From: Matt Brockhurst [REDACTED]
Sent: 13 September 2017 17:18
To: Simon Davis
Cc: Phil Wiltshire
Subject: RE: Y/52/17/DOC - Longacre, Maypole Lane

RE: Longacre Holiday lets Y/52/17/DOC

Groundwater Monitoring Log

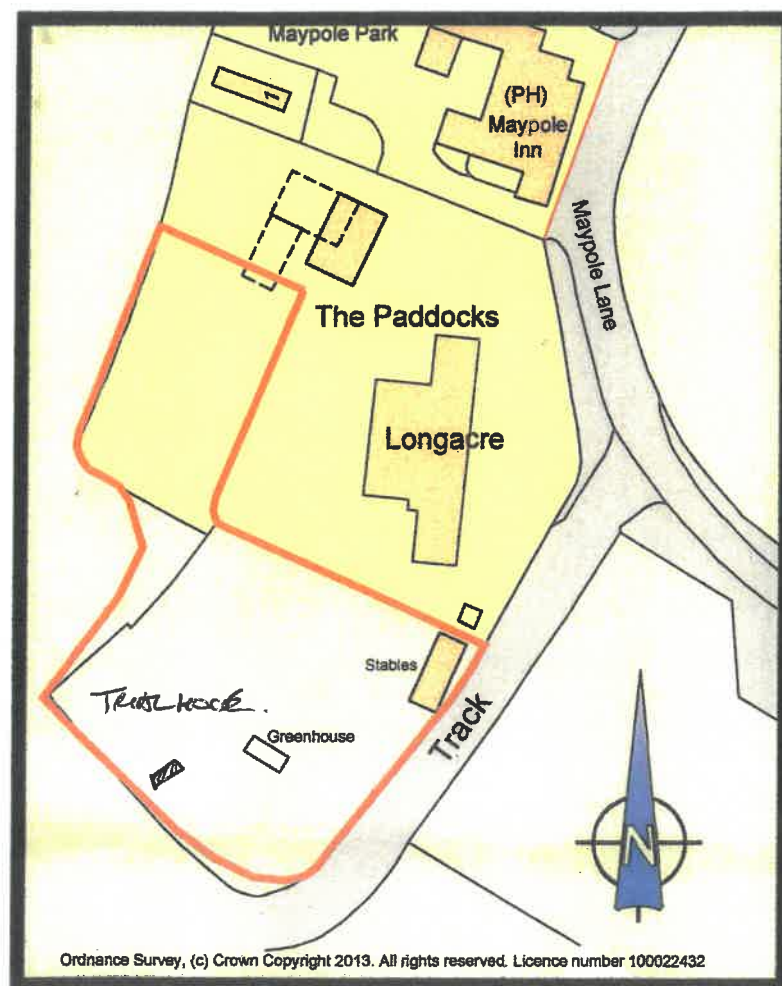
From our telephone conversation it sounded like you hadn't done any groundwater monitoring at all, which is the reason I was concerned. You now say in your email that you undertook trial holes in Feb 2017 and therefore I assume you noted the water table level (trial holes need to be left open for 24 hours to ensure any groundwater levels settle out). This data will need to be provided in support of your design.

holes were dug and monitored on the 13 February 2017 the results of which have been used for the calculation submitted.
